TOWN AND COUNTRY PLANNING ACT 1990

FULL

Reference:	H17-0028-26	Date of Decision:	5th June 2026
Applicant:	Mr J Heppenstall 20 The Reservoir Surfleet Spalding Lincolnshire PE11 4DJ		
Location:	20 The Reservoir Surfleet Spalding		
Description:	Demolition of existing dwelling and construction of new replacement dwelling and double garage

Drawing No - 1a

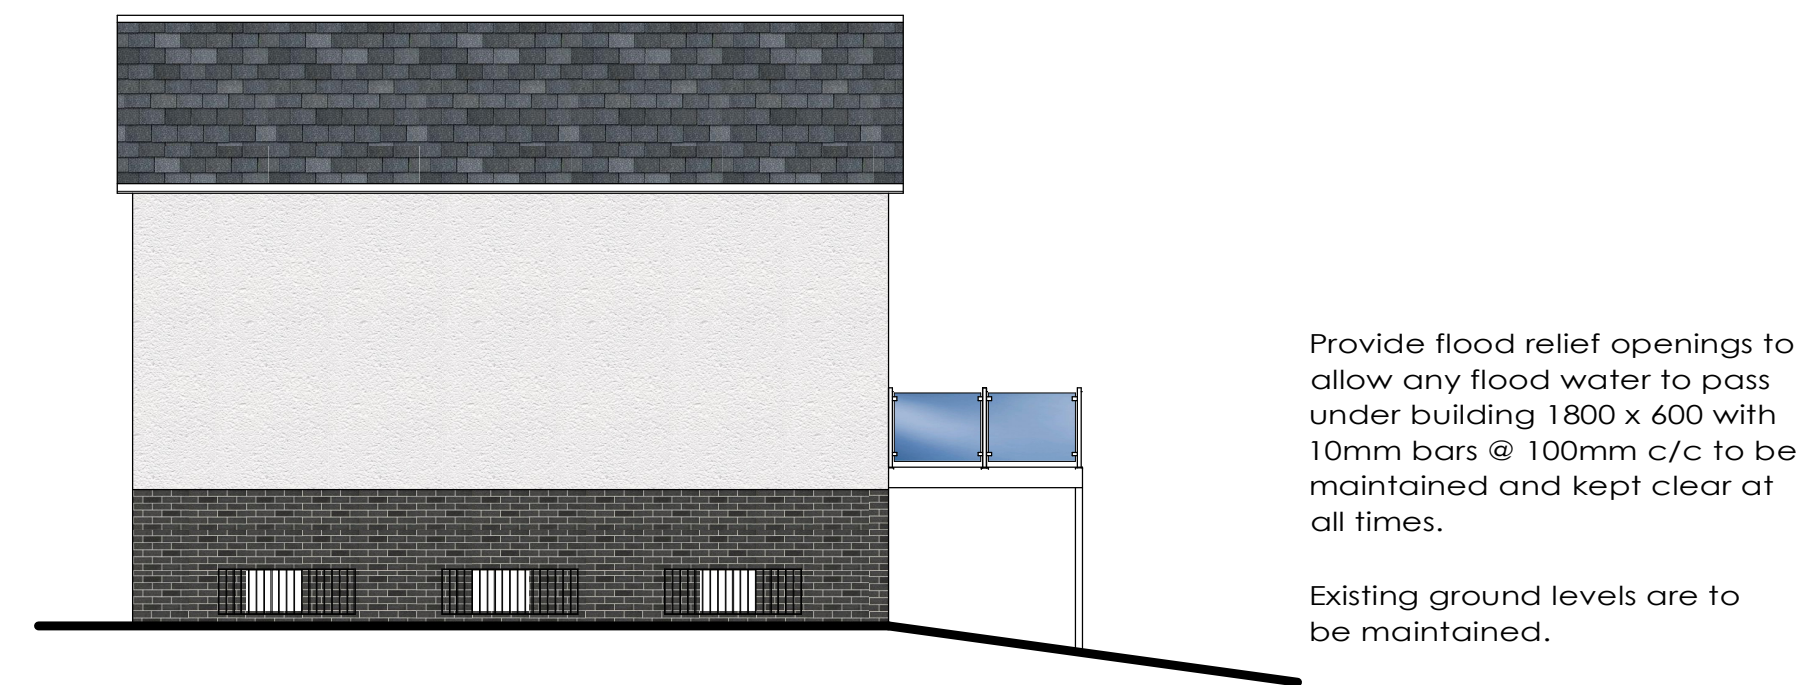
- 10 Notwithstanding the details submitted, before any part of the development hereby permitted is occupied, the following window(s) shall be installed with obscure glazing (to a minimum level of Pilkington - Privacy Level 3 or an equivalent product).

- The eastern side elevation windows.

Under Floor Void

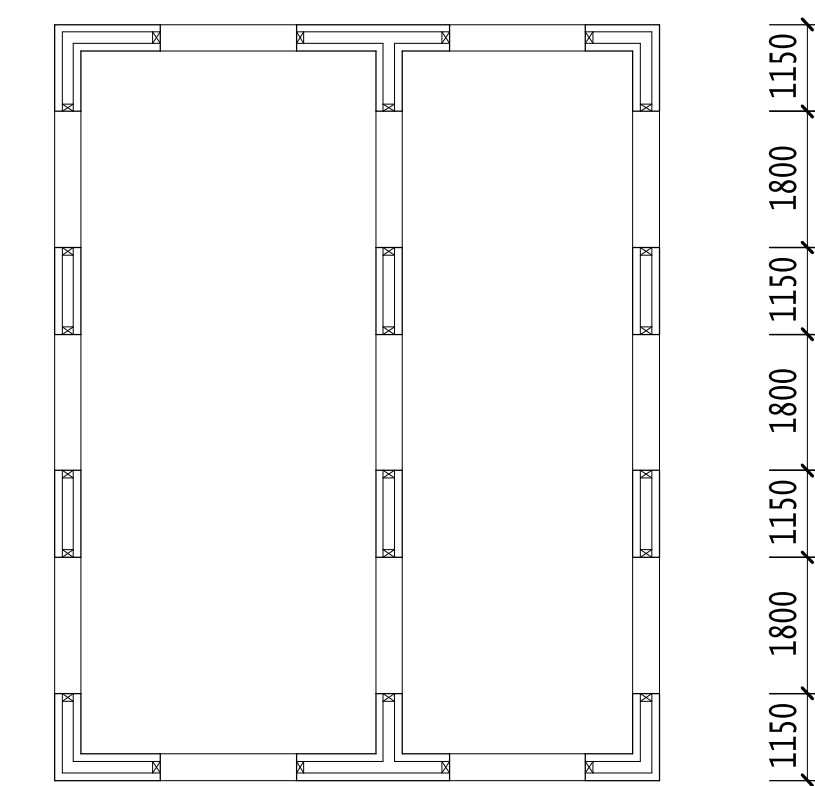
- 6 The development hereby permitted shall be carried out in accordance with the measures set out in the Flood Risk Assessment (ECL1235a/L BLISS) forming part of this planning application. In particular, the following measures shall be fully implemented before the property is first occupied:

- The finished floor level of the dwelling shall be set no lower than 5.40 metres above Ordnance Datum (mAOD);
- The built footprint of development (dwelling and garage) shall not exceed 103.4m²;
- Voids shall be included on all elevations of the dwelling and shall be 1.8m wide and 0.6m deep;
- The security bars in the void openings shall be 10mm in diameter and at 100mm intervals;
- There shall be no ground raising on site; and
- Flood resilience and resistance measures shall be incorporated as stated.

Existing Site Plan 1: 200 @ A1

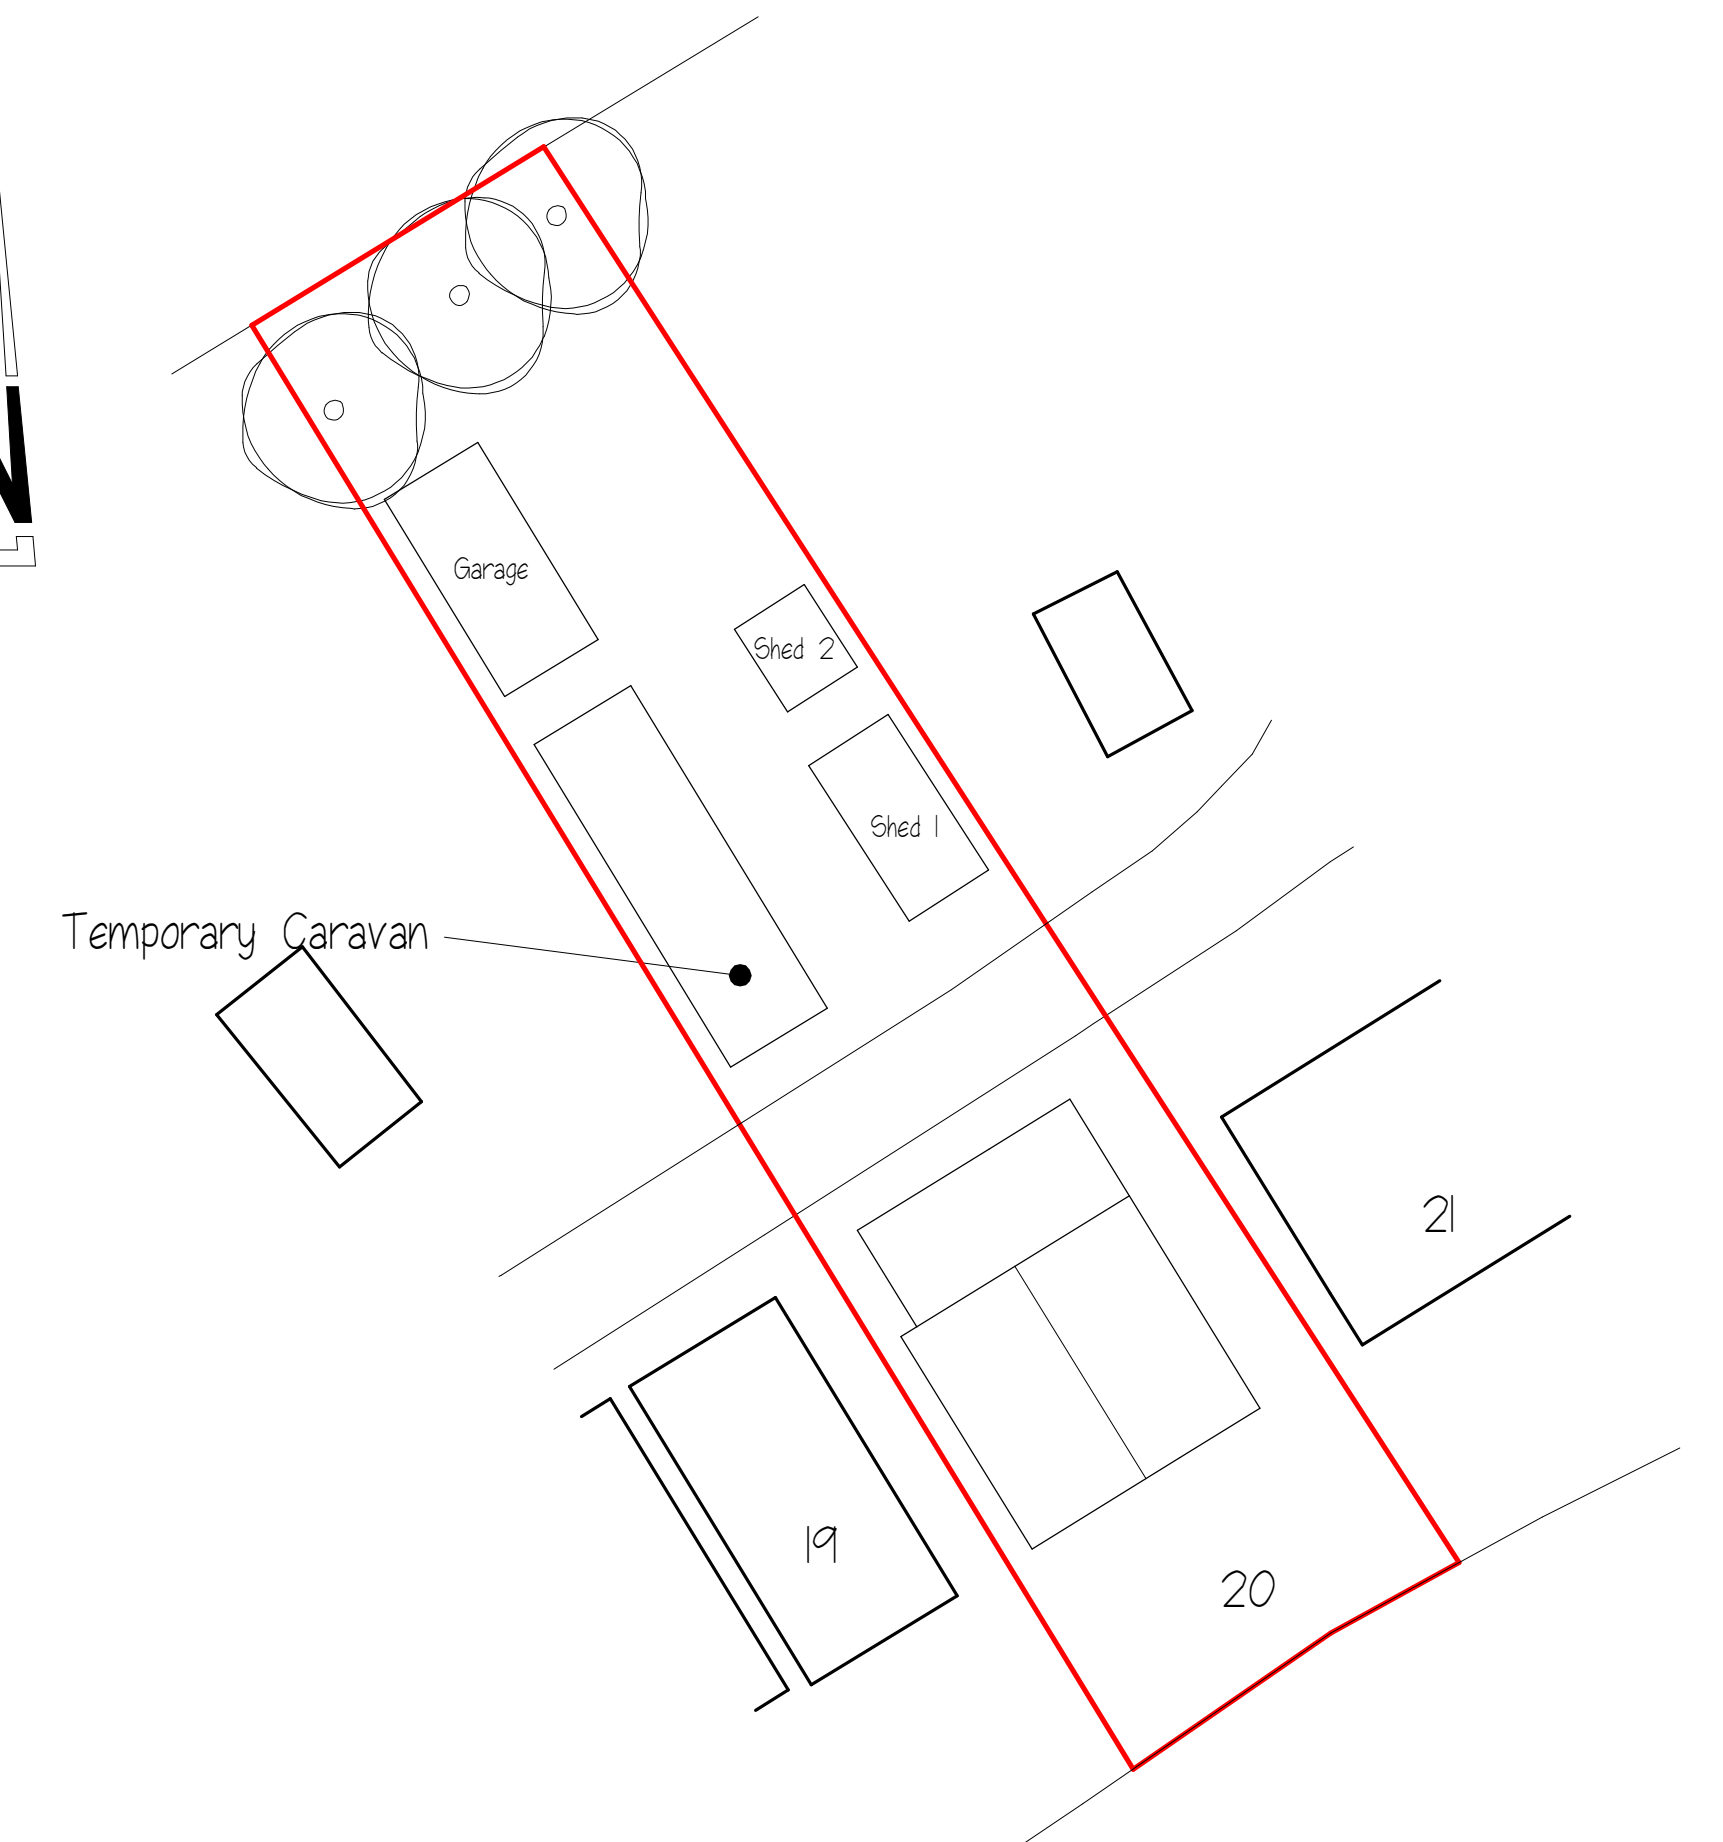
- 5 The temporary caravan as shown on the existing site plan on approved plan 2a shall be removed from the site at or before the first occupation of the replacement dwelling hereby approved.
